City of Sydney

4 May 2012

Environmental Assessment for Sydney CityGrid Stage 2A(ii)

# 01. O'Connell Street concept design

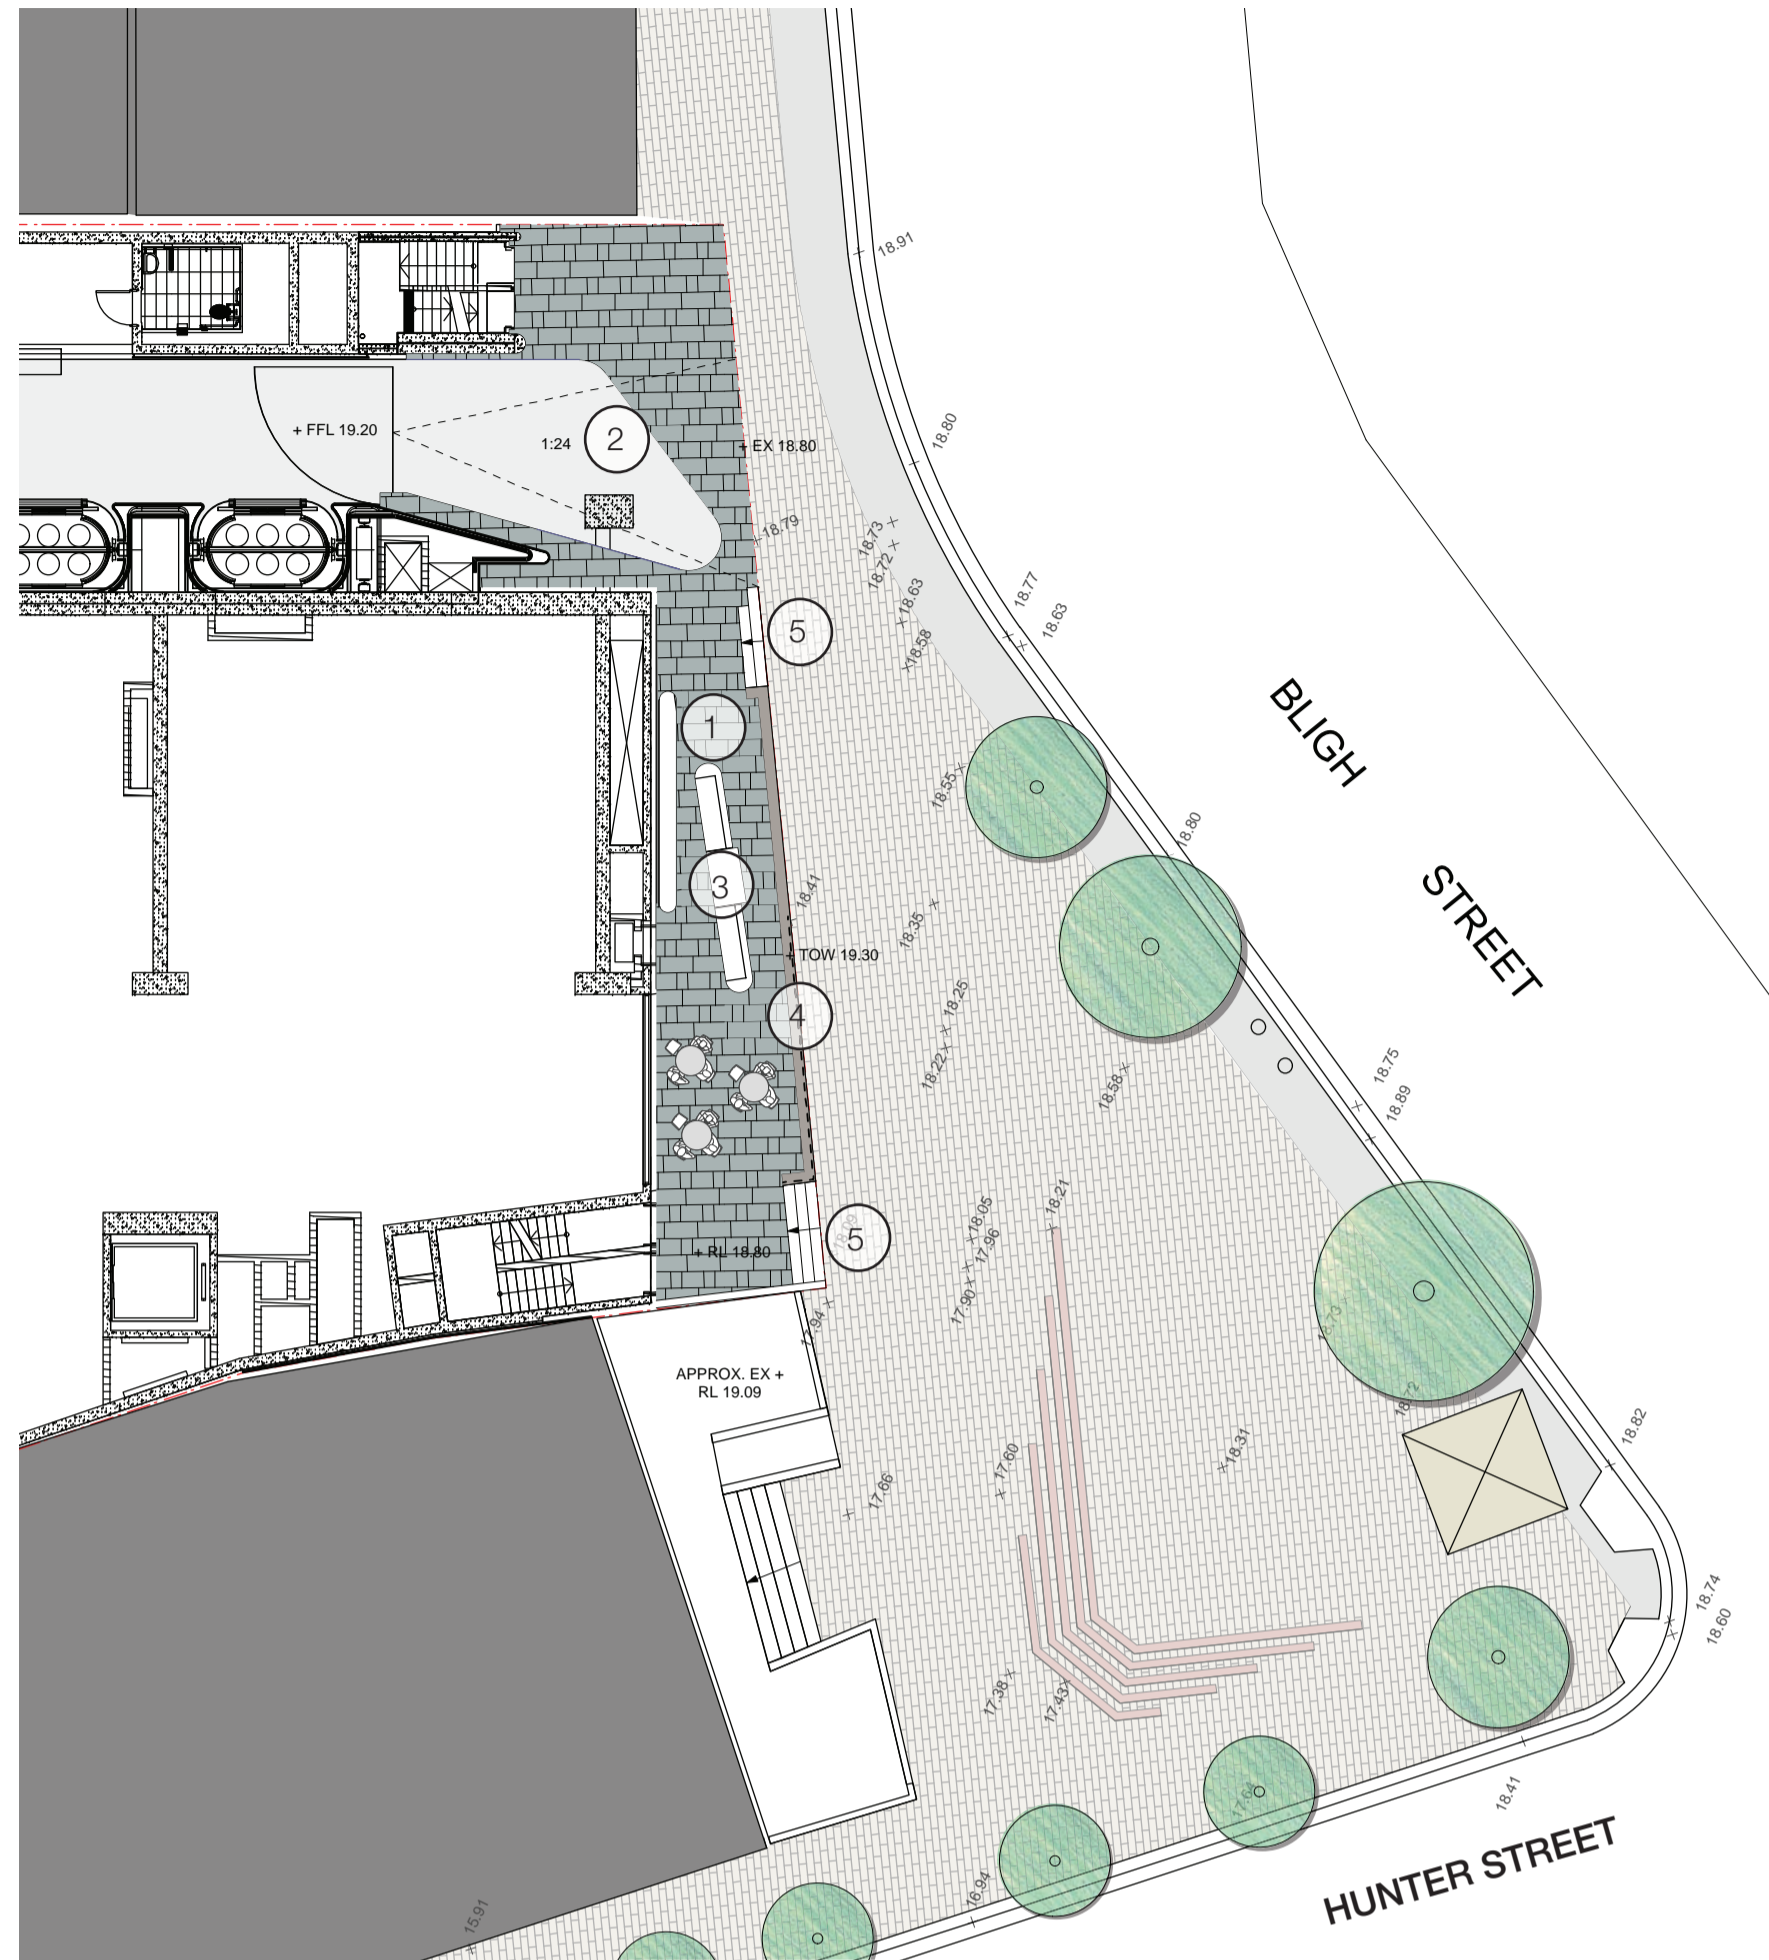
and a blank facade. There is a small amount of activation provided by a pedestrian entry to the escalators. There are potential pedestrian and vehicular conflicts on O'Connell Street as the driveway to the car park is next to the pedestrian entry to the escalators. The base building has not been set back a minimum of 500mm from the O'Connell Street frontage above the height of the arched granite base of AFT House at 16-18 O'Connell Street. Furthermore, the ground level facade is predominantly blank for about two thirds of its length.

- 10. The report notes that it is proposed to provide an 11m wide driveway crossover for the Ausgrid trucks. This is accompanied by a swept path plan included in the report (Figure 6). The Architectural Plan (PA - 05) and the Public Domain Plan (11042 - LPA01) however show a much smaller driveway crossover. This discrepancy needs to be resolved.

- (d) Provide some internal space to the proposed cafe on Bligh Street to ensure its use and activation of Richard Johnson Square in all weather conditions.
- (e) Provide a glass line at ground level for O'Connell Street with doors as a 'line of defence' after hours instead of the proposed fencing/security gate.
- (f) Reduce the conflicts between pedestrians and vehicles along O'Connell Street by co-locating the driveways to the southern boundary.
